Major Project 09_0166 – 'Altitude Aspire' at Fraser Drive, Terranora, South Tweed Heads.

I refer to your letter dated 21 February 2001, your reference 09_0166.

Roads and Traffic Authority

BROADWATER PARKWAY
LAYOUT

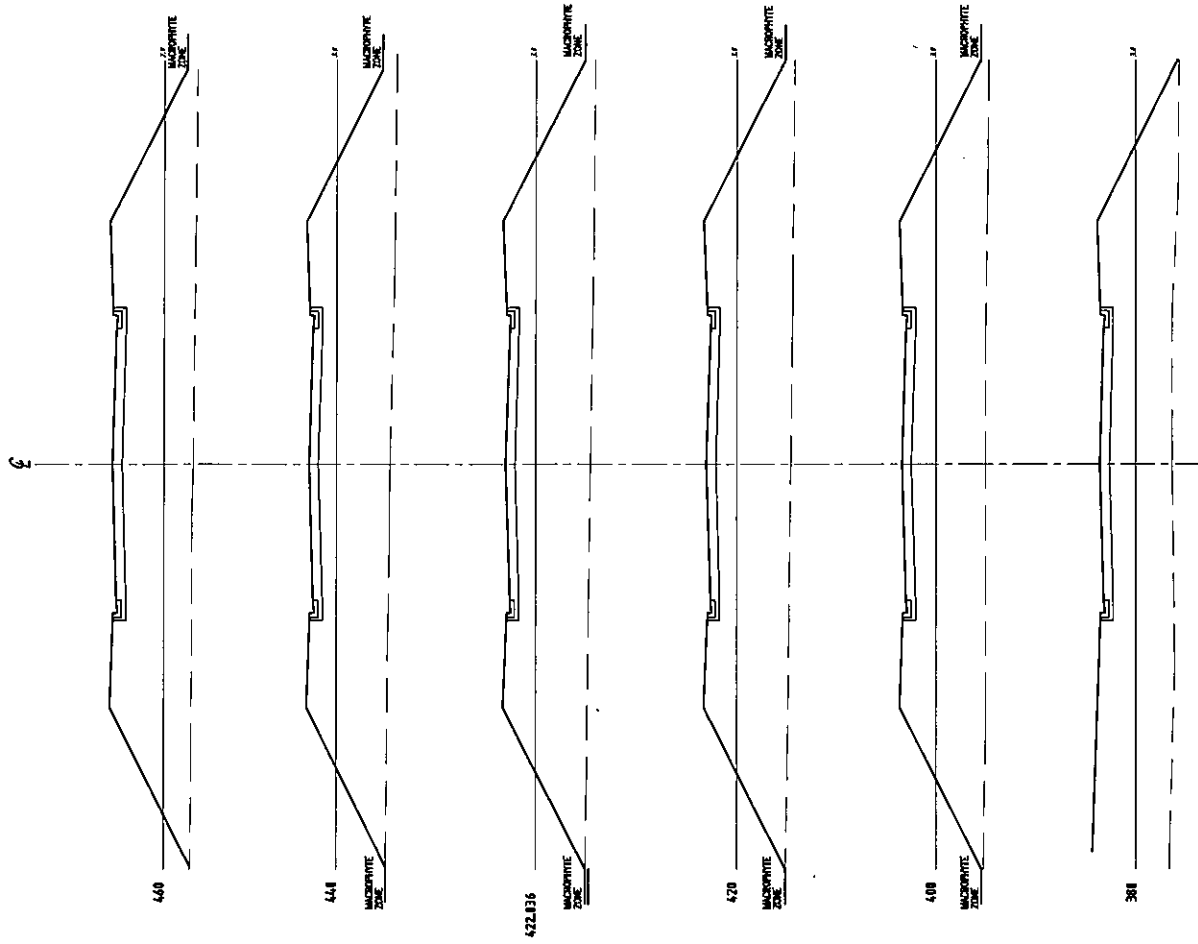
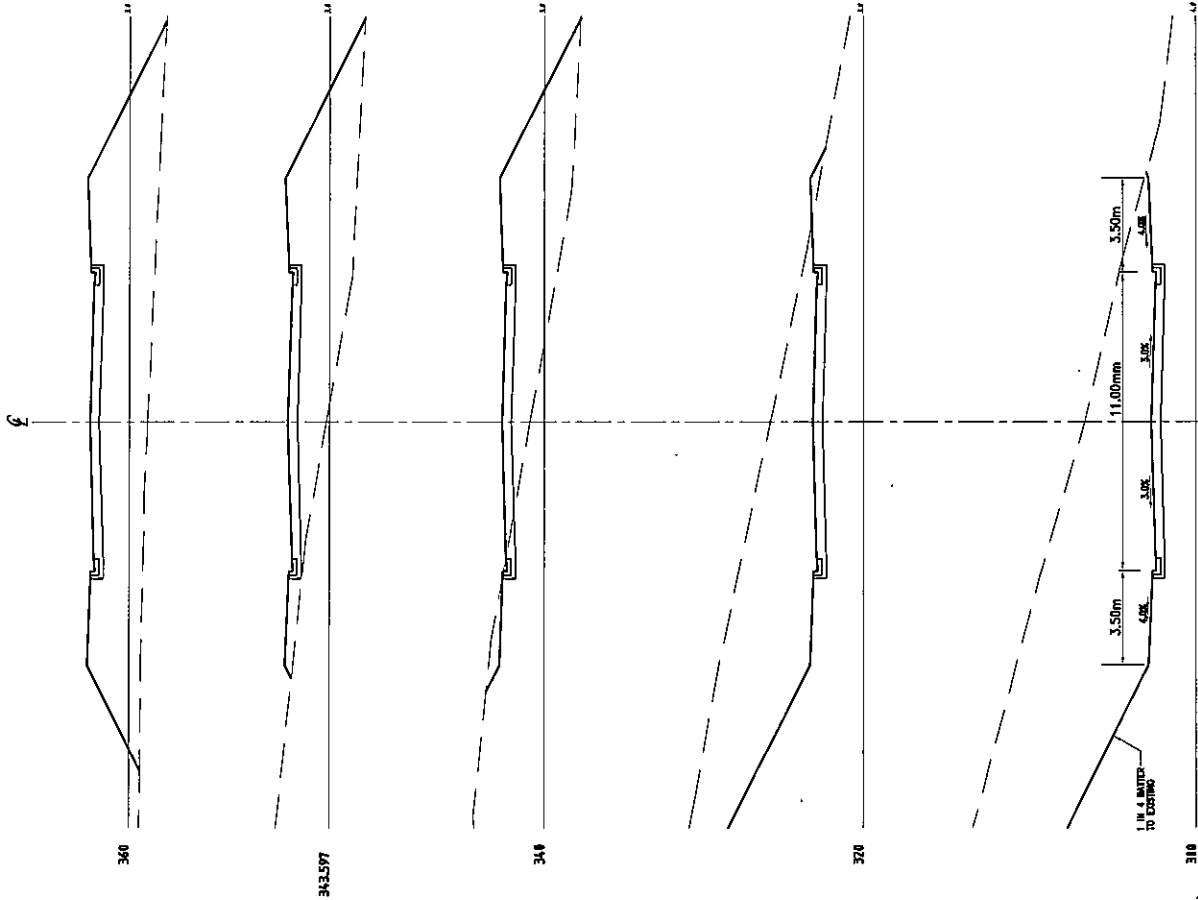
The traffic modelling supporting the proposal assumes in the future traffic signals will control the intersection of Fraser Drive and Broadwater Parkway. The installation of traffic signals will require approval of the RTA before adopting this method of intersection control. To ensure the RTA requirements for signals are met, consultation with the RTA will be necessary before traffic signals can be installed.
